From: Sarah Burrow
Sent: 13 January 2022 10:16
To: [REDACTED]
Cc: [REDACTED]
Subject: RE: BN/150/21/HH - 1 Bateson Way, Barnham

On the basis of Drawing BH BW 03A – which I would like uploaded to the portal. I ask that my request for the application to be conditioned is disregarded. Surface water drainage must be constructed in accordance with said drawing.

Sarah Burrow
Engineering Assistant, Engineering Services

BH/BW/03

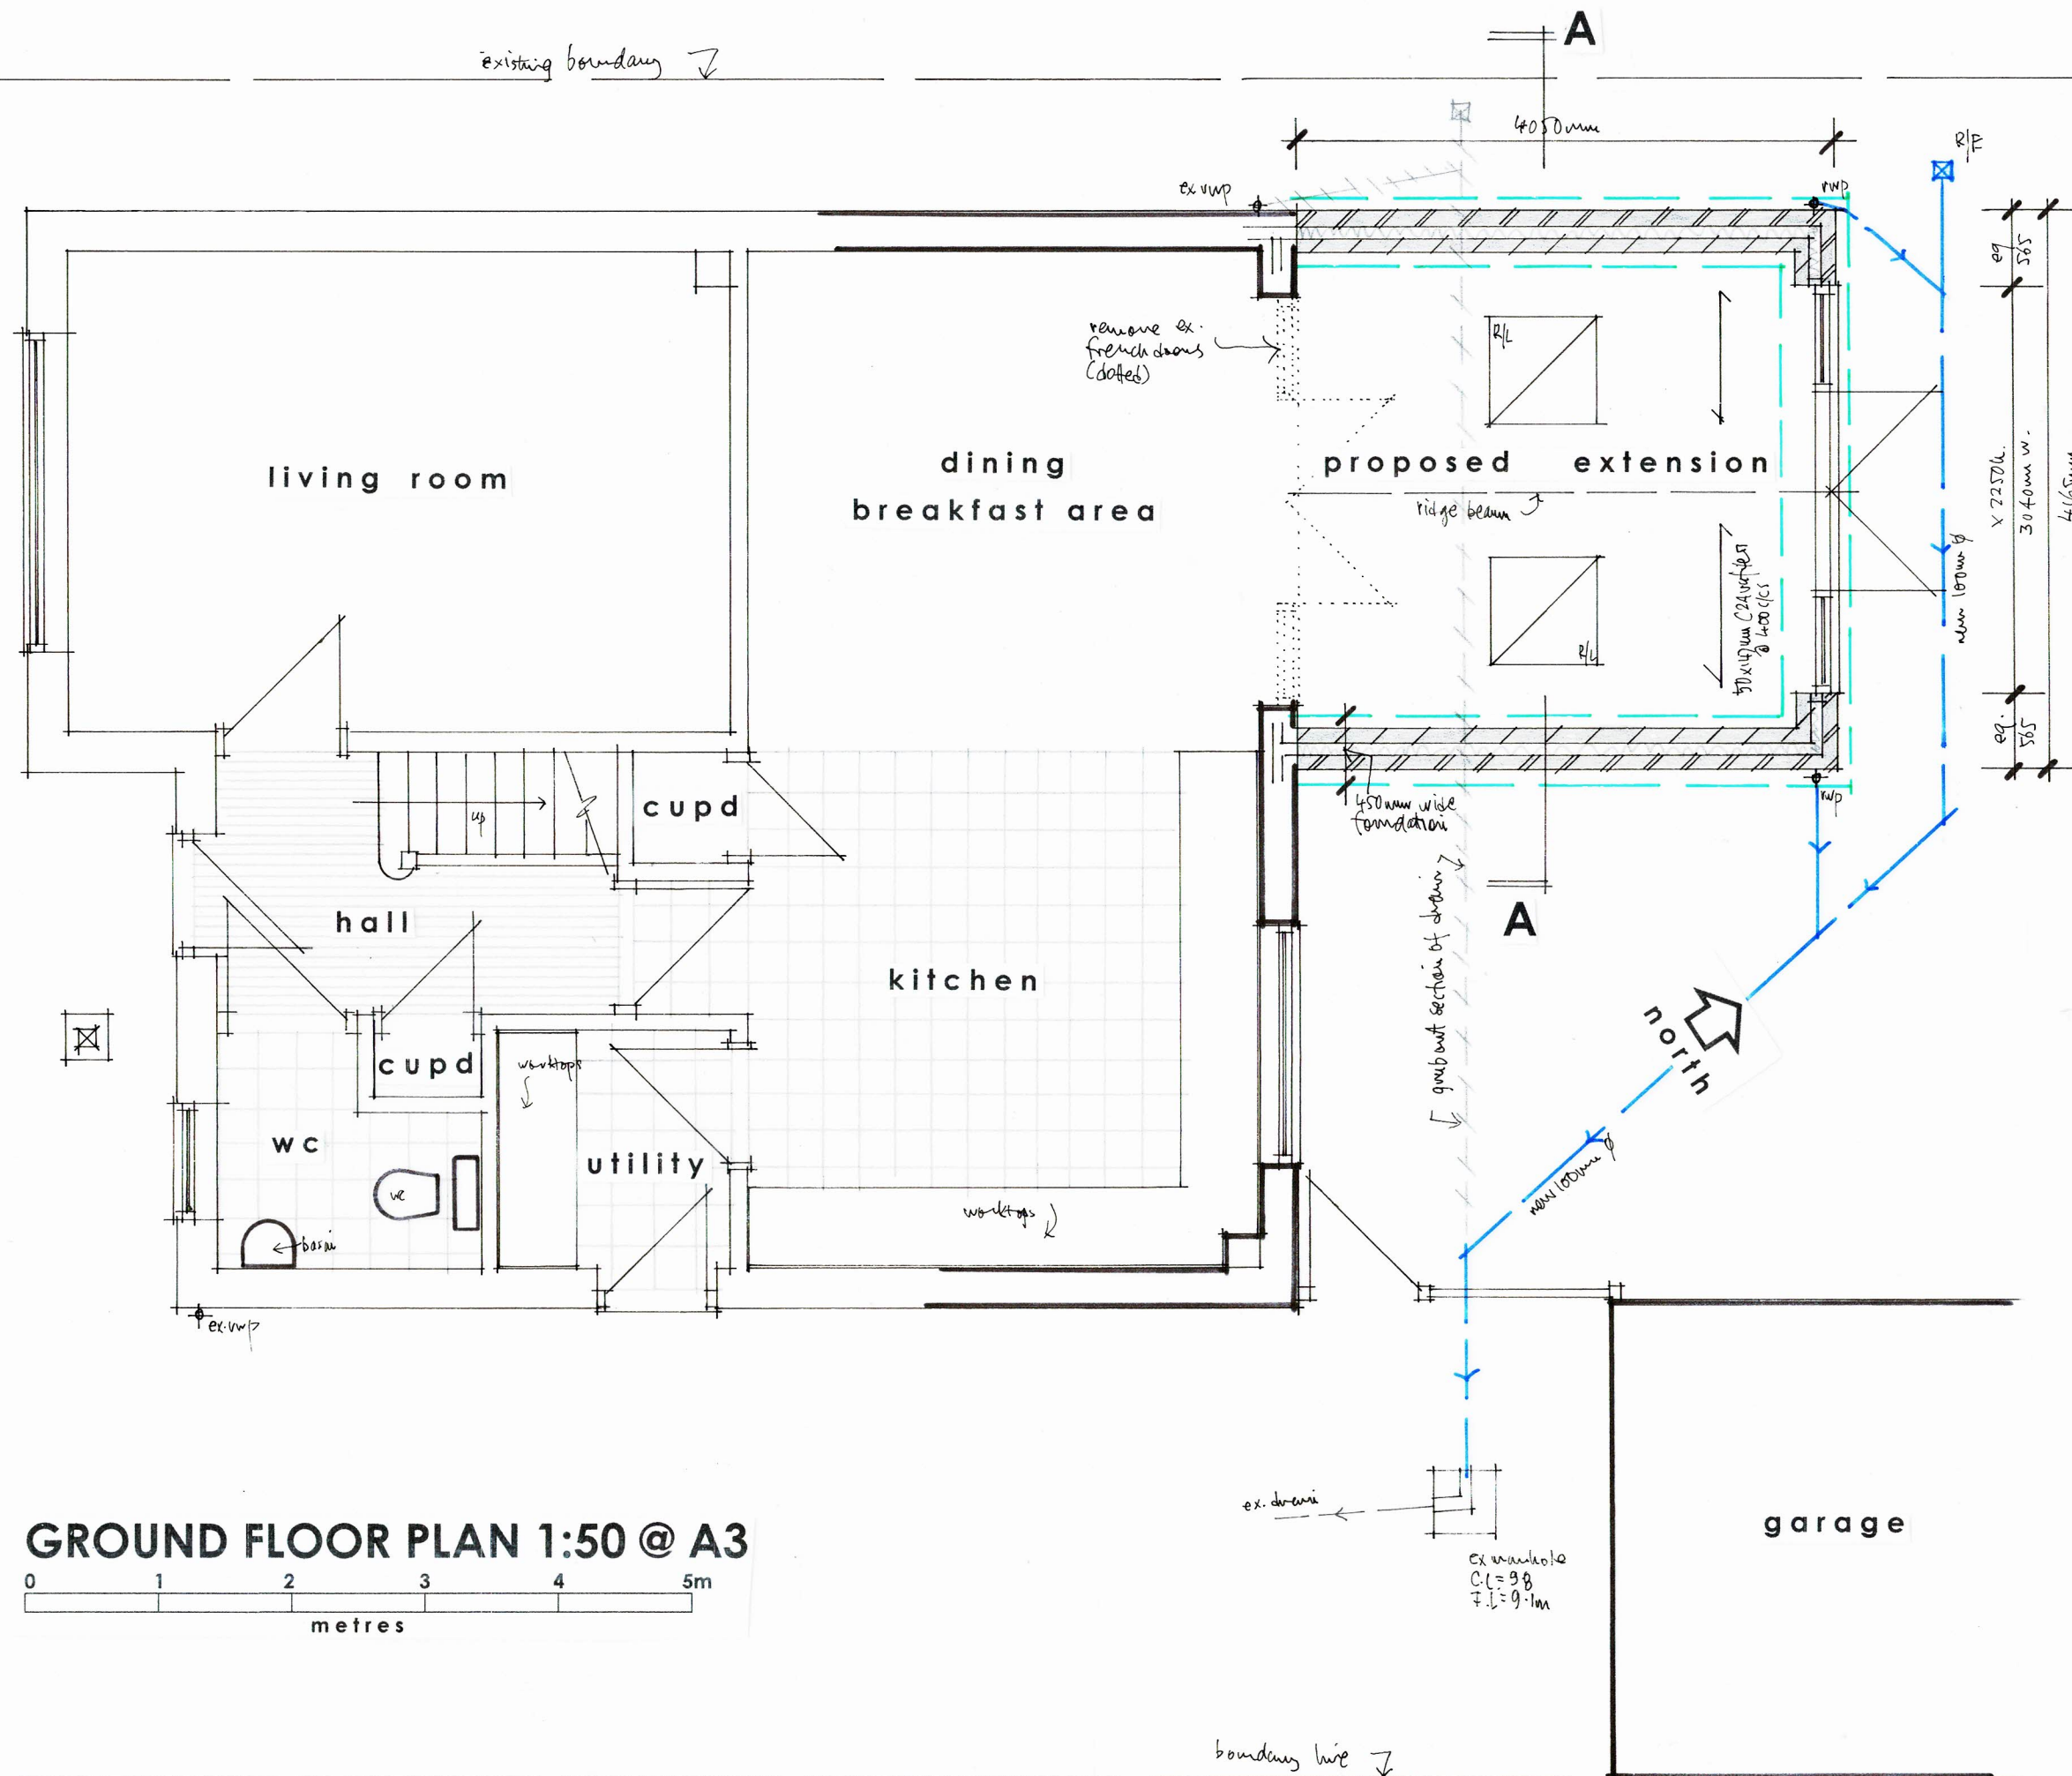
The planners have been in touch and are in support of our proposal but are seeking to add a condition, this is not unusual. The council drainage engineer has advised a soakaway for the extension rainwater (which is the preferred traditional method) is not suitable due to poor porosity of the ground conditions. They stipulate we must connect into the existing surface water drain/manhole in front of the garage which in turn drains into a water course. Not into the foul sewer and certainly not into a soakaway. I see no reason not to agree to this. The only reason they will condition it is because they do not know the exact position of the drain and this would have to be confirmed on site. If the drainage is as we believe we would not build over the drain but connect the existing house downpipe into the extension rainwater goods thus removing the section of drain under the new extension, see my sketch.
